Planning Application No:3/2021/0275

I am expressing my concerns regarding this application because of the adverse effect it would have on

Site Section through The Dog Inn, Plot 2 and 36 Darwen Close

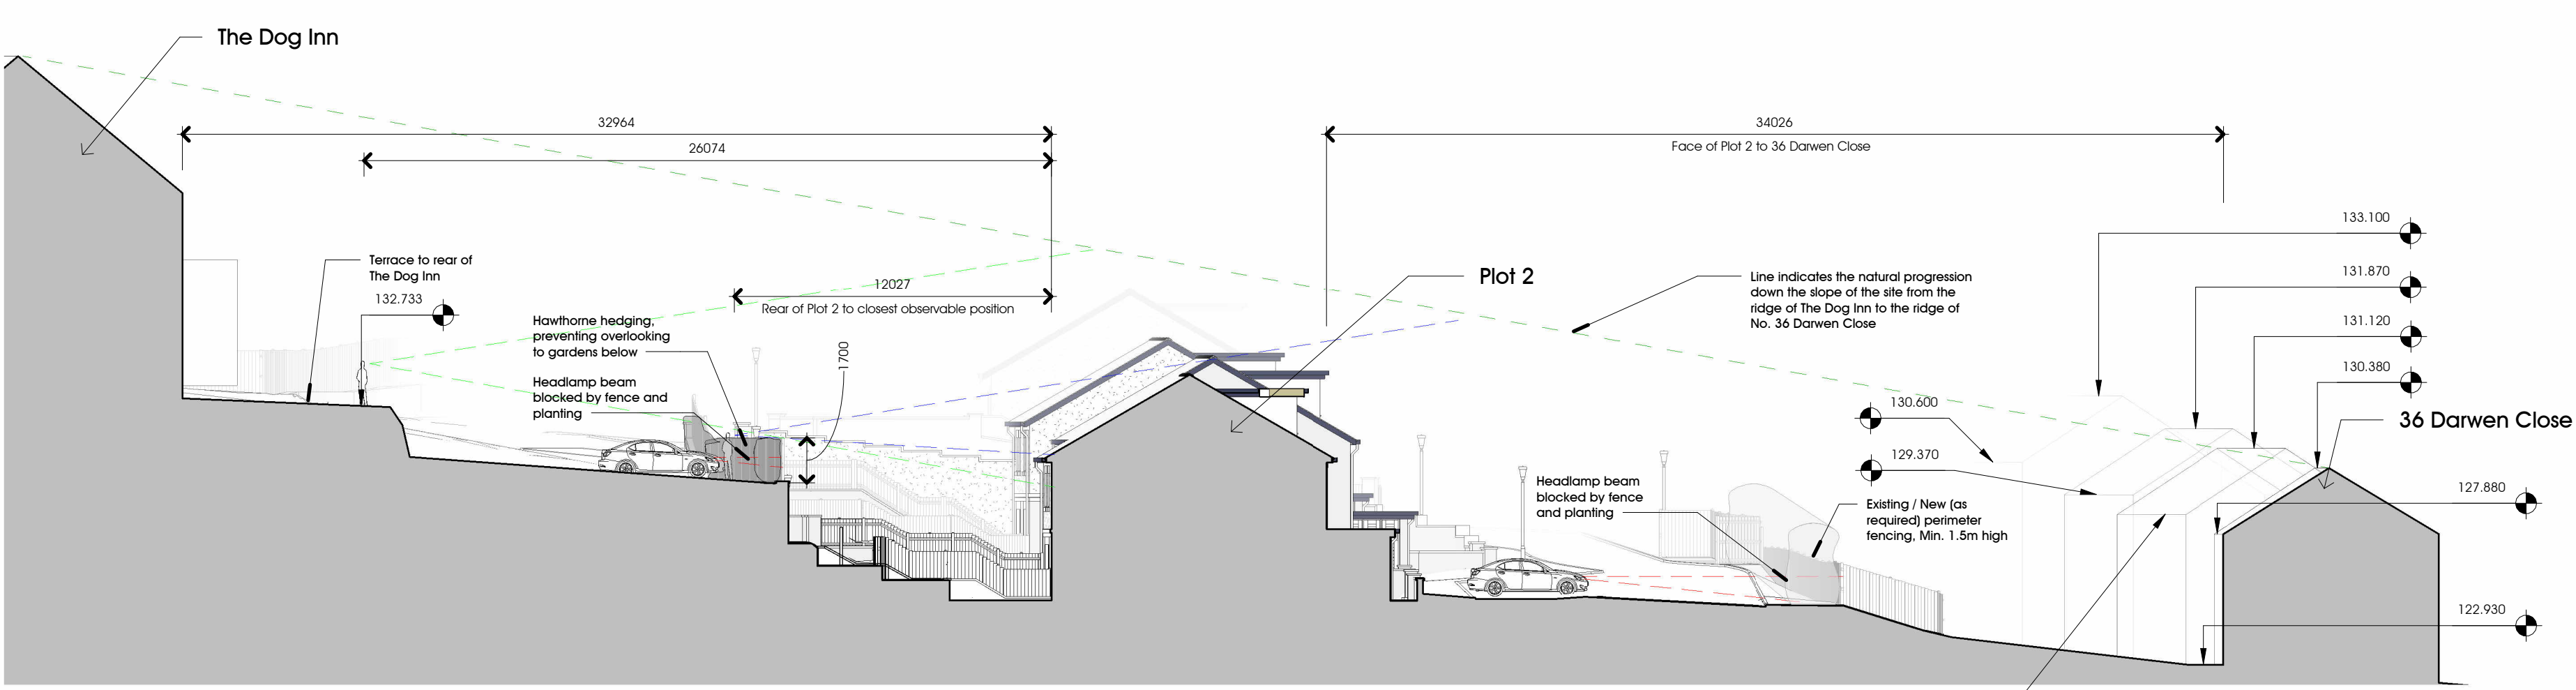
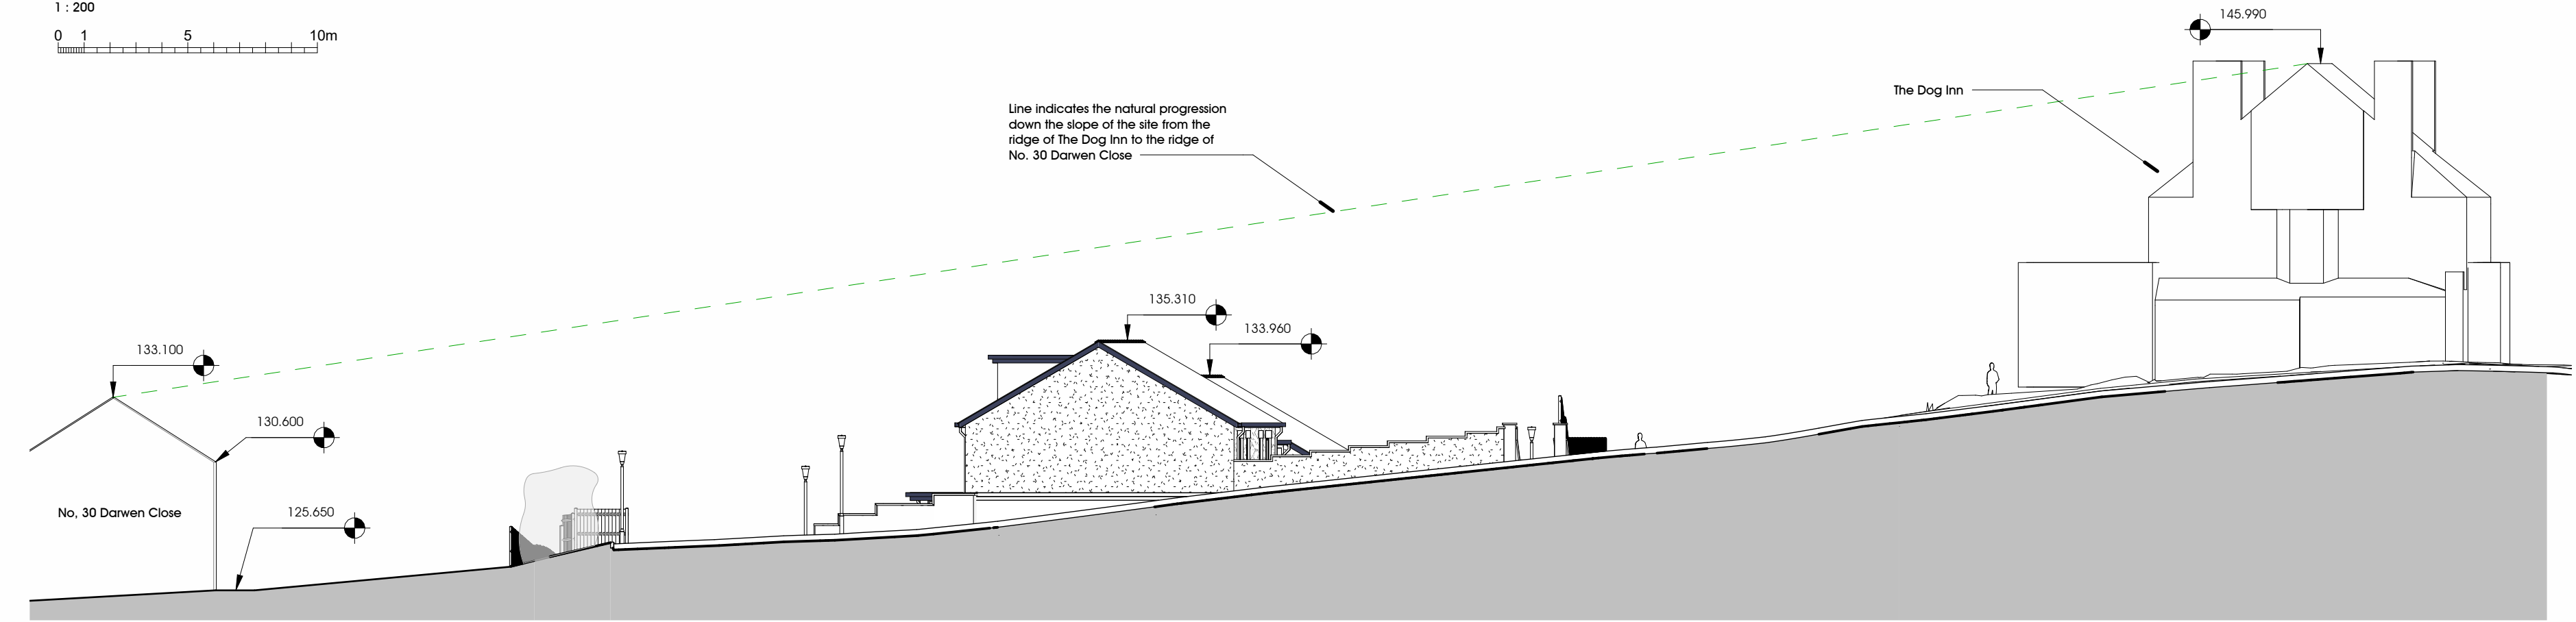
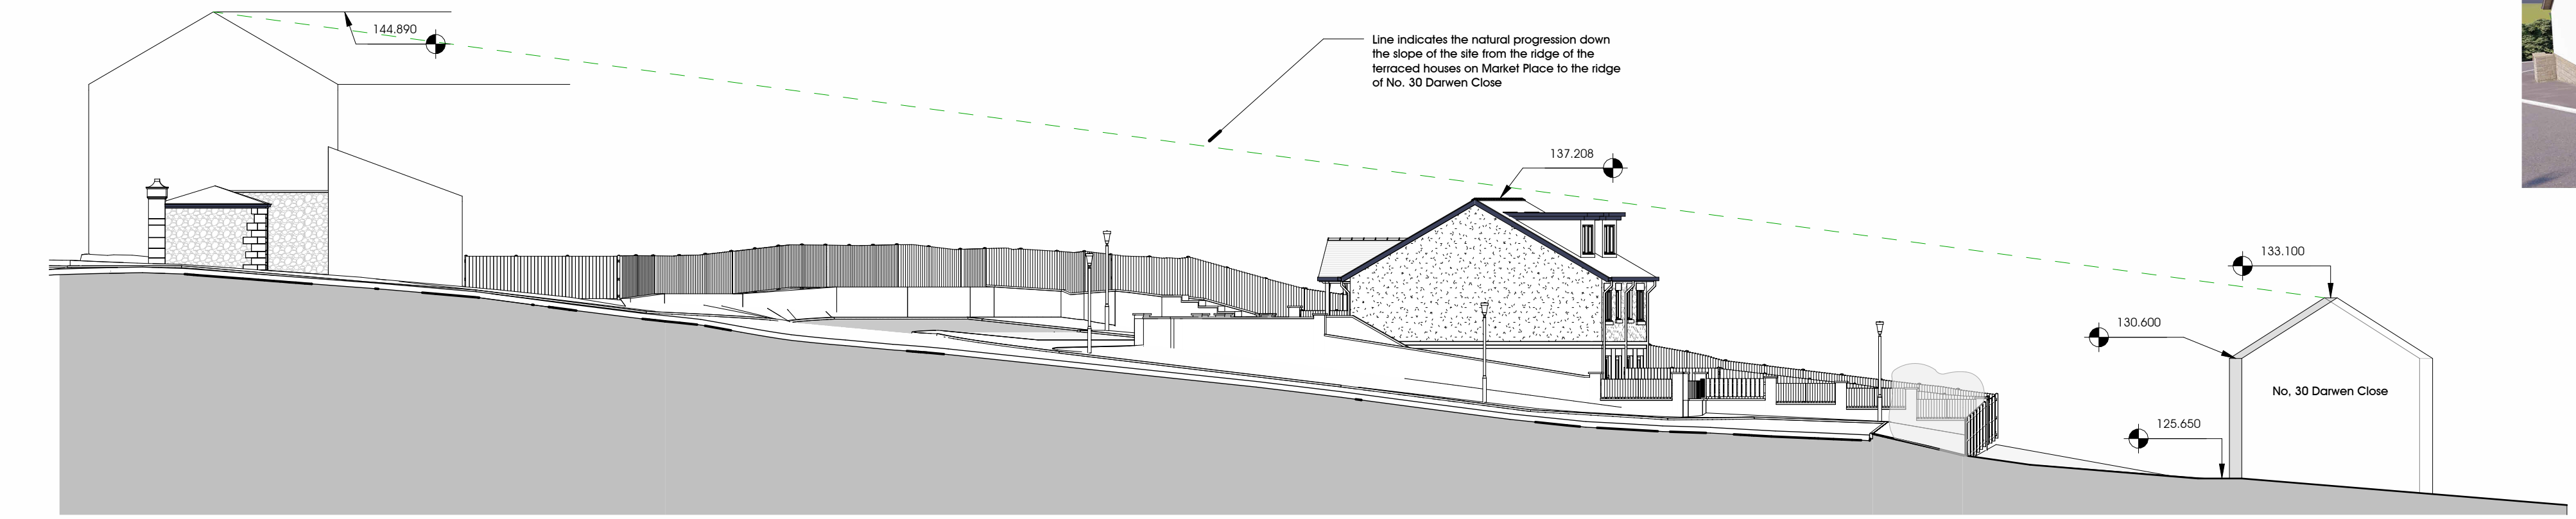
The properties on Darwen Close are considerably lower than on the proposed site. I am therefore concerned regarding the height of all the houses to be constructed, but particularly on plots 1,2,3 and 4. The houses on plots 1 and 2 will be over 5 metres and those on plots 3 and 4 will be the second seco

Proposed Site Plan
1 : 200
0 1 5 10m

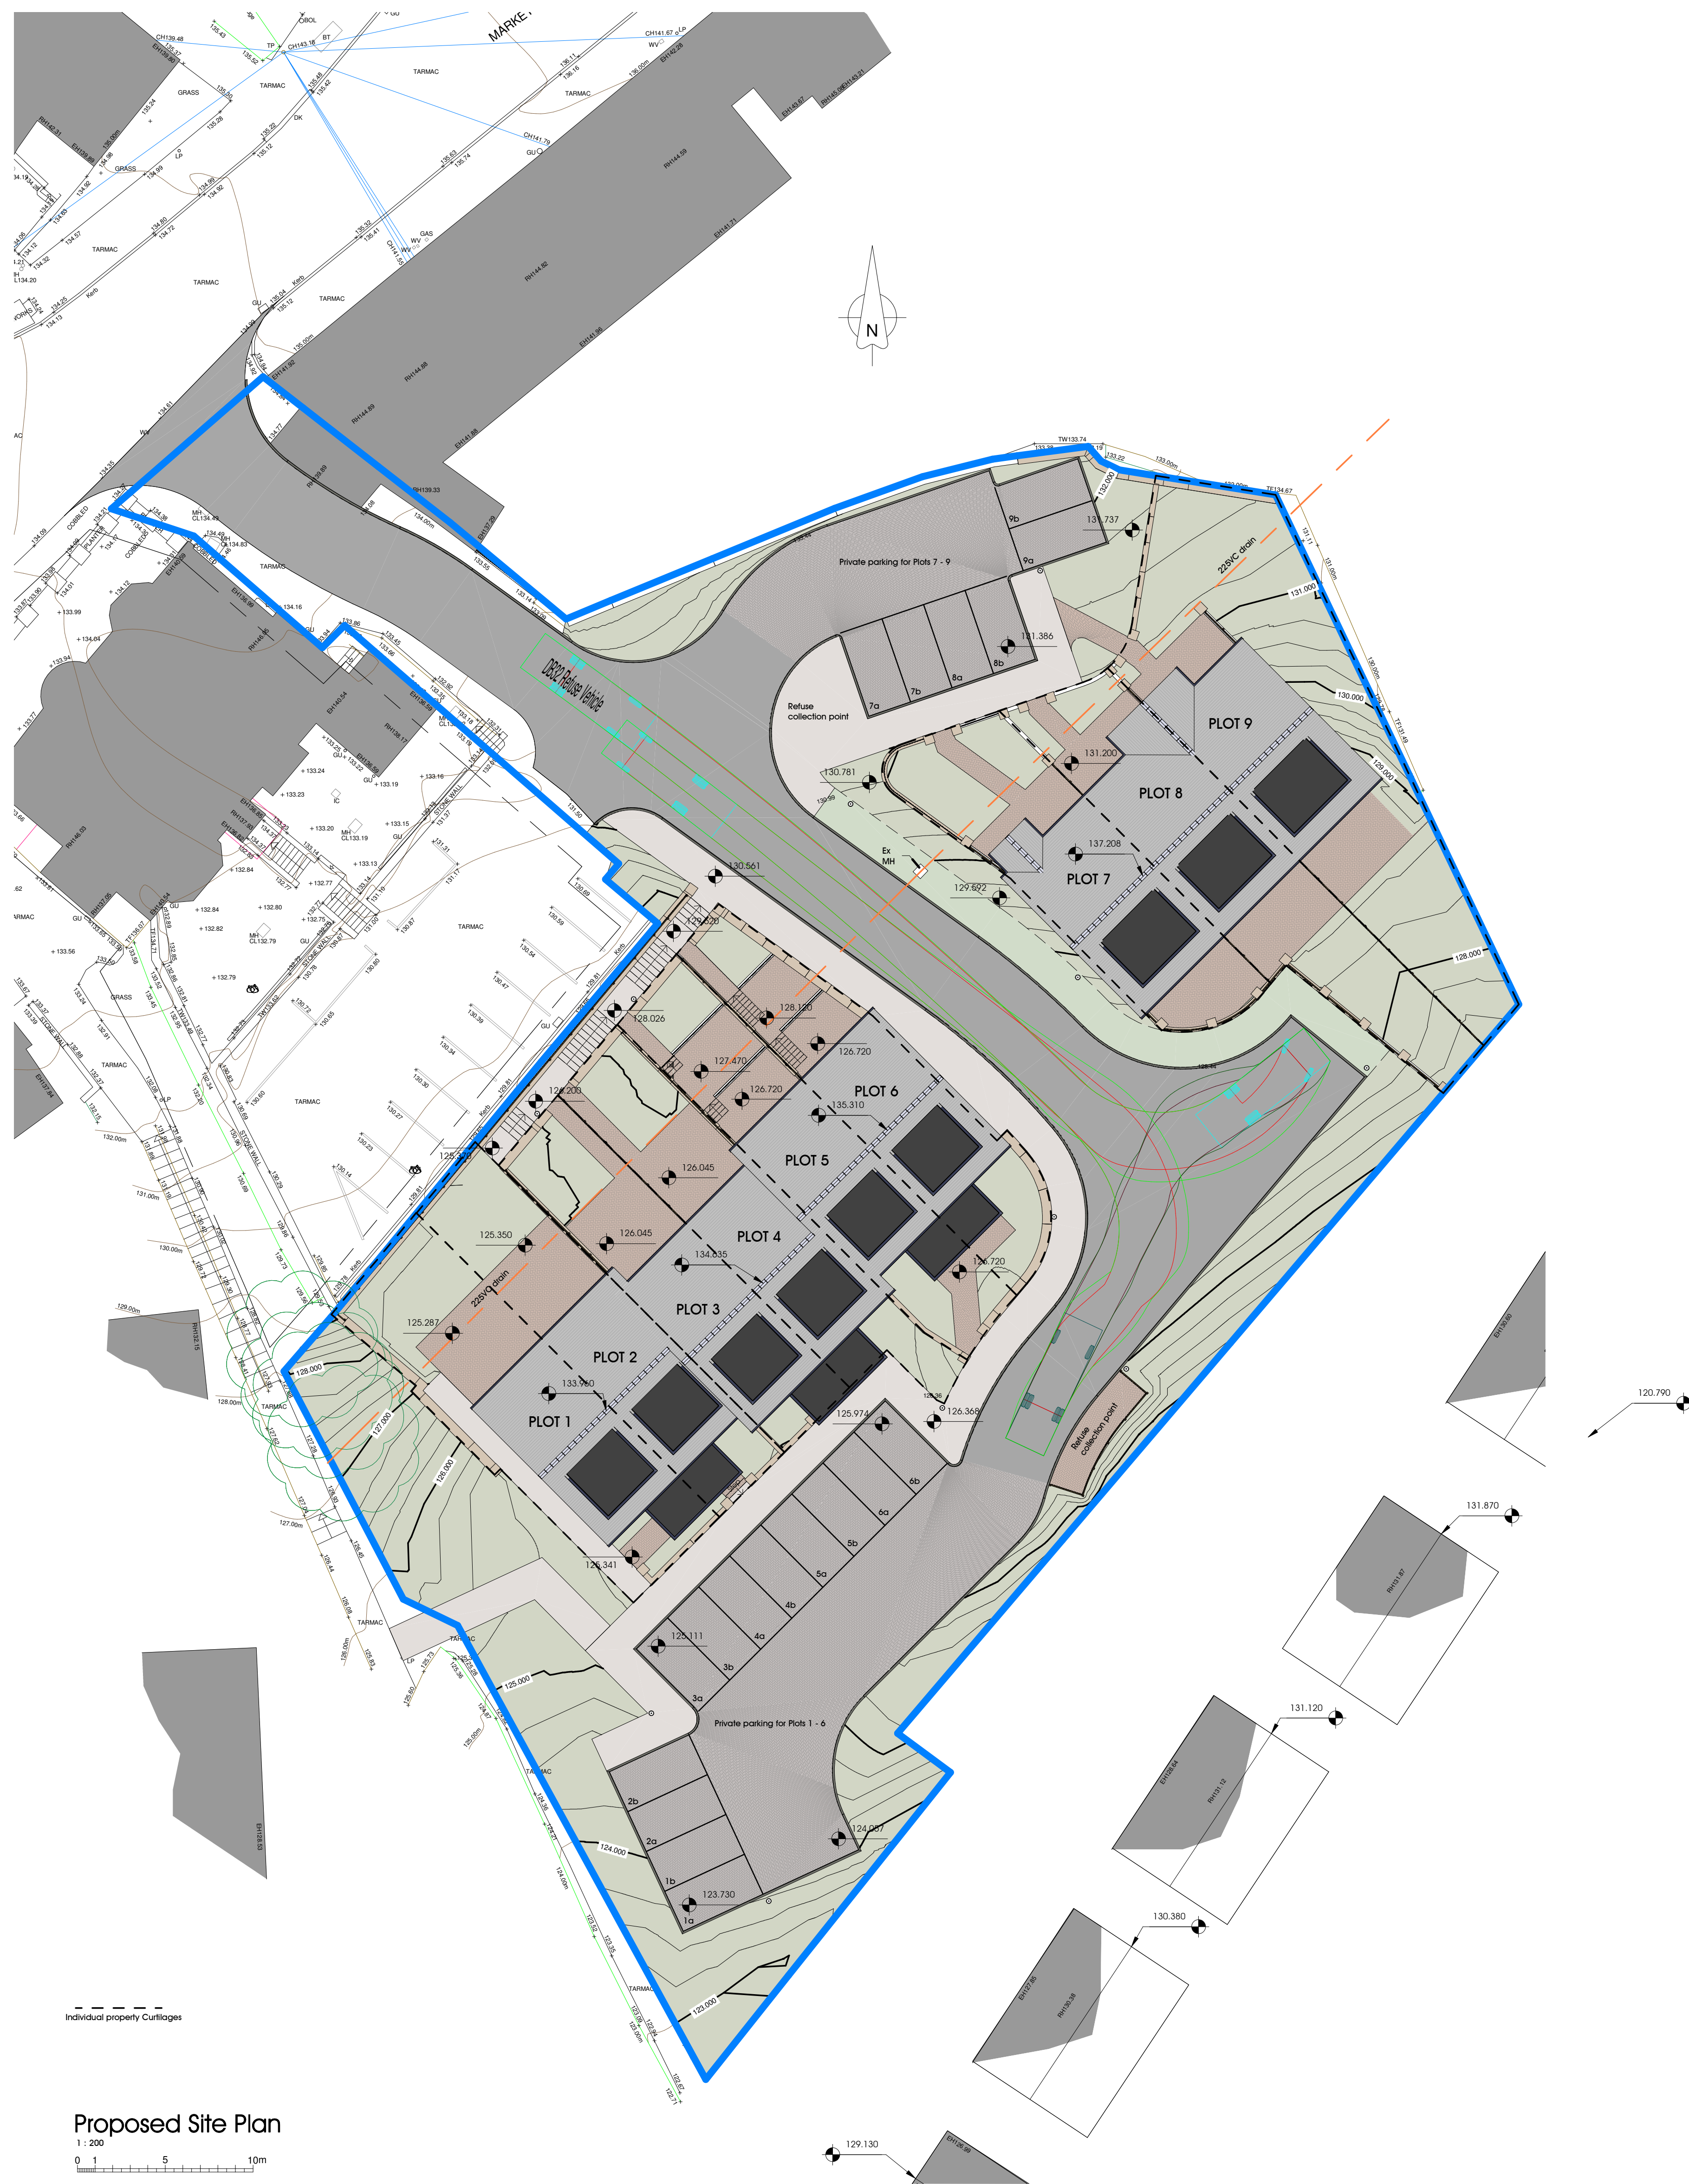
At a similar time the contours of the land **sector** were radically changed to enable the building of plots 1,2,3 and 4 and to facilitate the construction of a very steep road. The incline of this road with a sharp bend will be very dangerous if a vehicle was to lose control, particularly one as heavy as a dustbin lorry. The turning point and access for the collection of refuse is at the bottom of this road on the boundary of my property. The headlights from traffic using this road will also have a direct impact and be detrimental.
